Rezoning Transportation Analysis

Petition Number: #2022-105

Date	Description
11-28-22	First Review (PM)

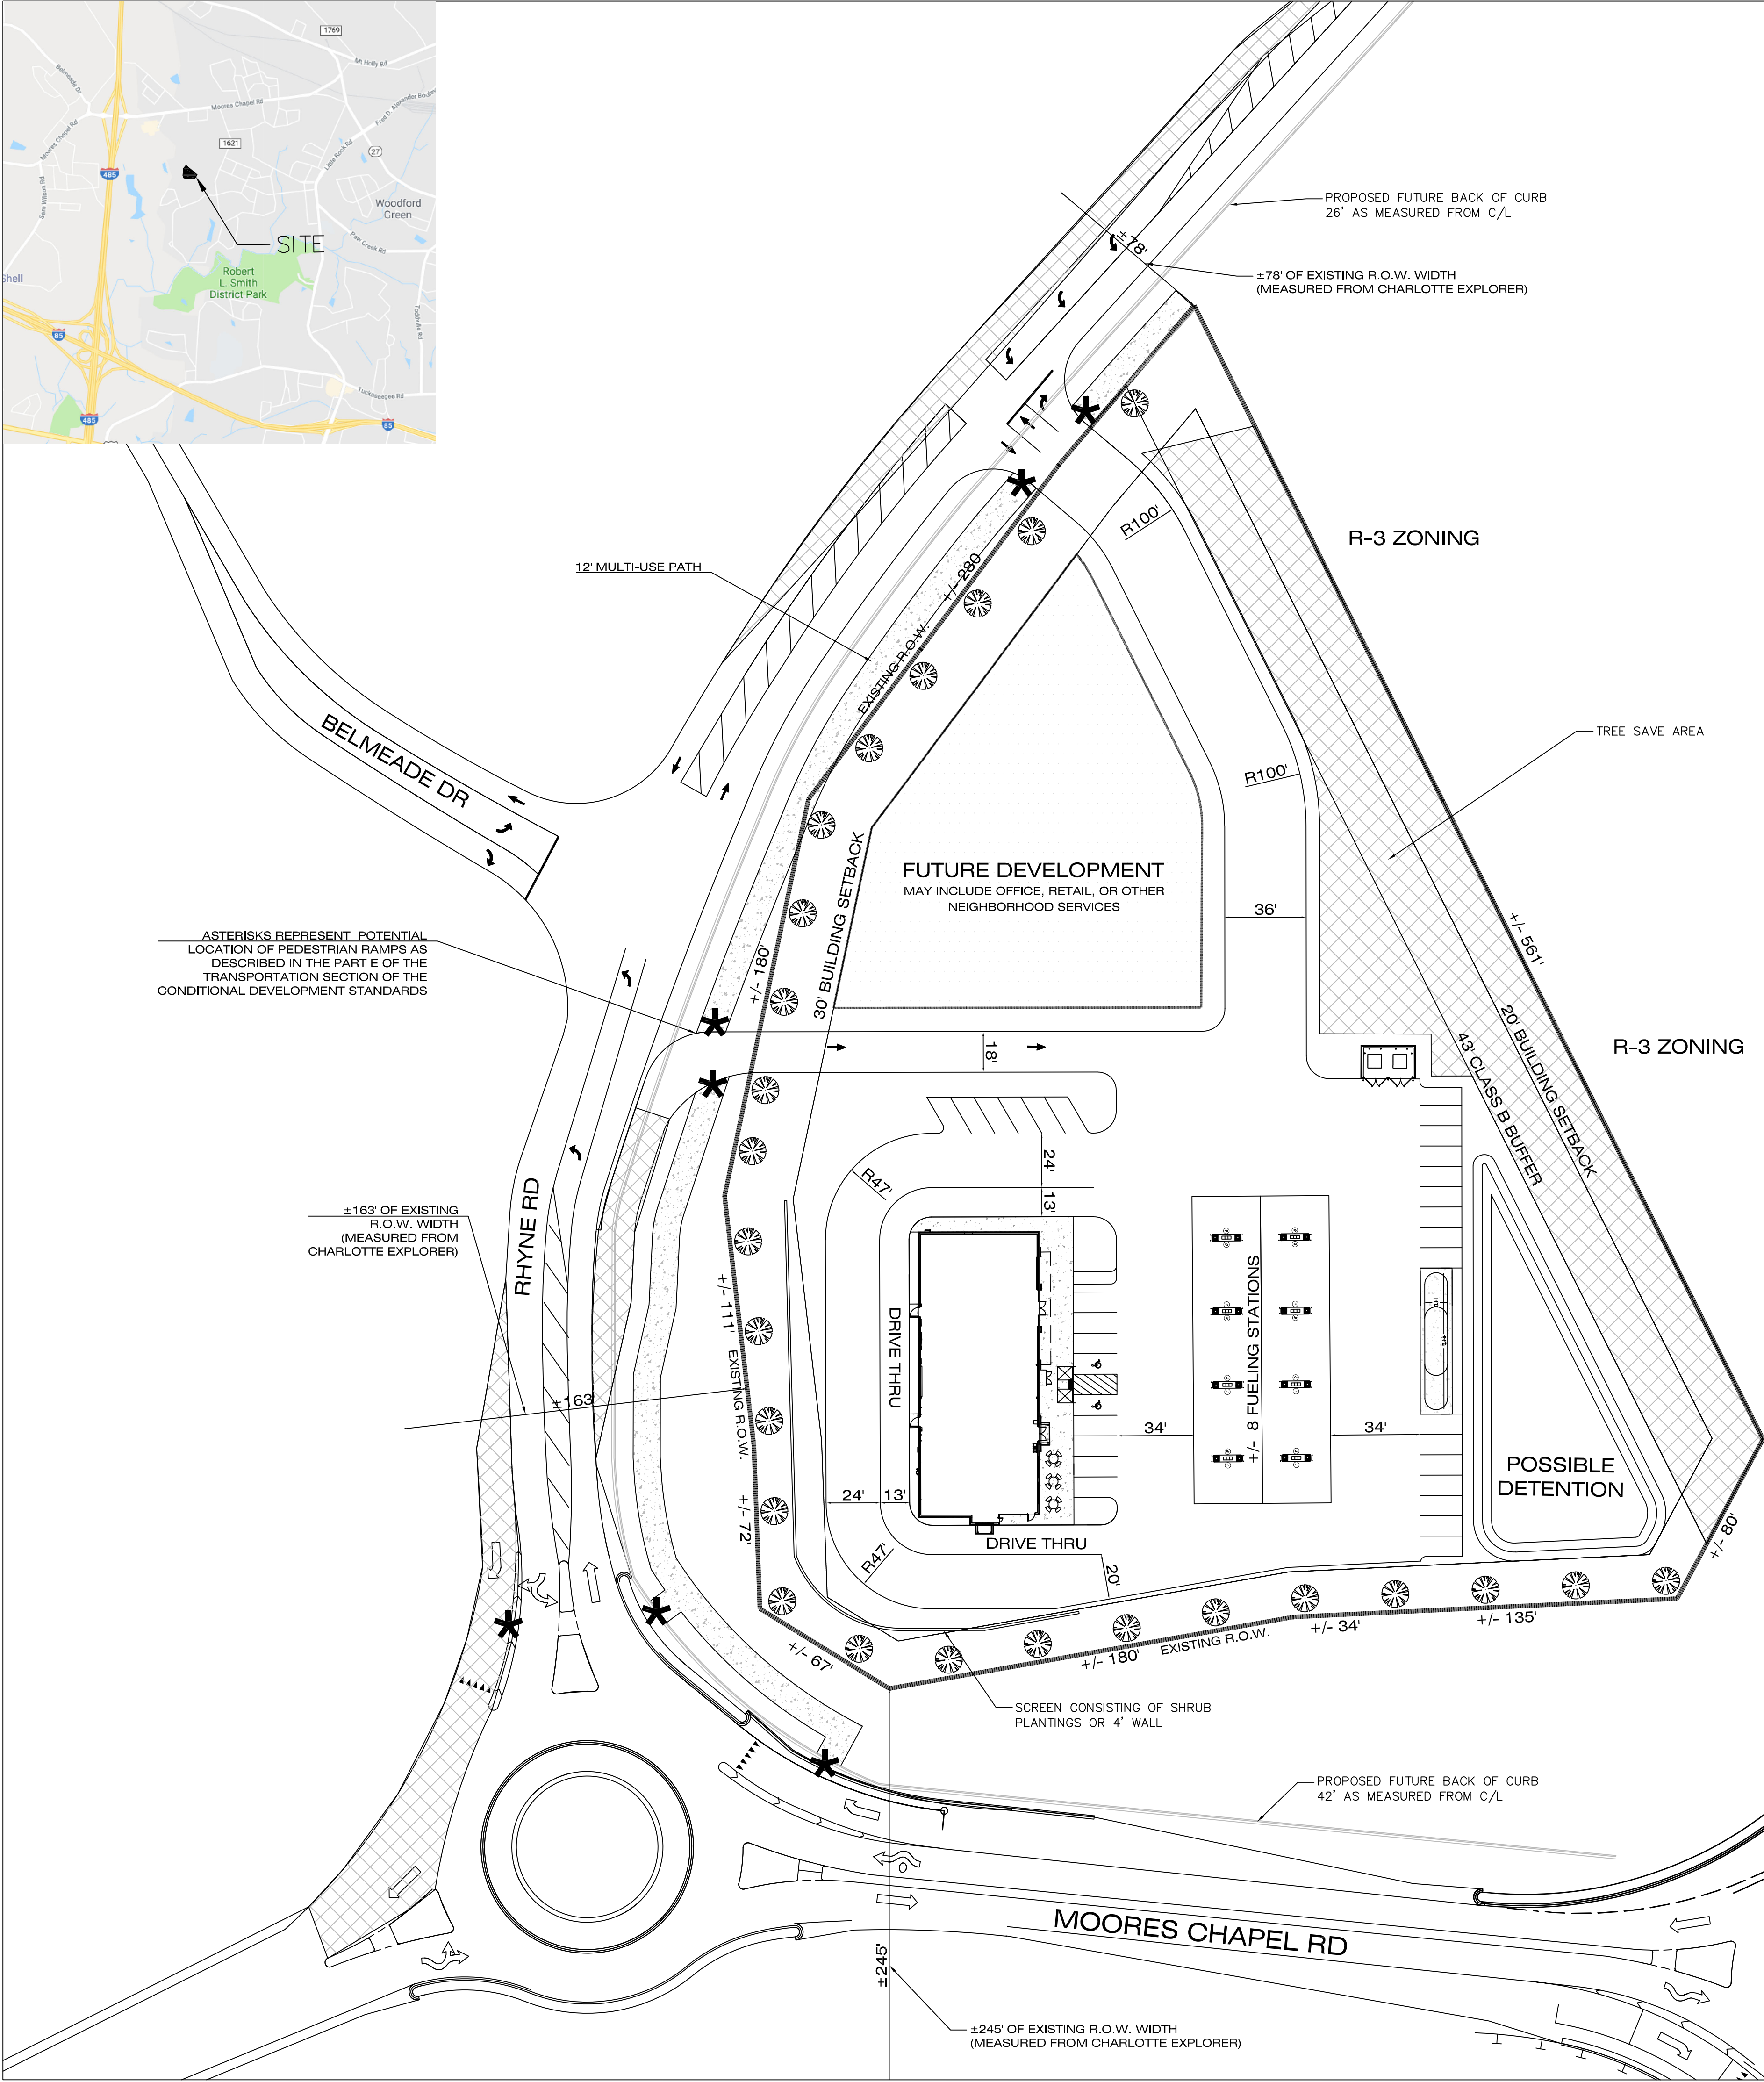
2. Revise site plan conditional note in the transportation section letter e. for Southbound I-485 Off Ramp to say, "Extend existing southbound right turn lane to provide 400' of storage and appropriate taper."

REWORD:

Extend SBR to provide 400' of storage and appropriate taper.

Existing SBR is 200'.

3. Revise site plan and conditional note(s) to provide 12-foot multi-use path and 8-foot planting strip along all public road frontages (Moores Chapel Road, Rhyne Road, Belmeade Drive). Revise the ramp locations and conditional note Transportation Note E to include the additional ramps that will be required. Provide SUE located 2-feet behind sidewalk if located outside of the ROW. Add conditional note to coordinate Control of Access Break with NCDOT for proposed multi-use path along Moores Chapel Road.
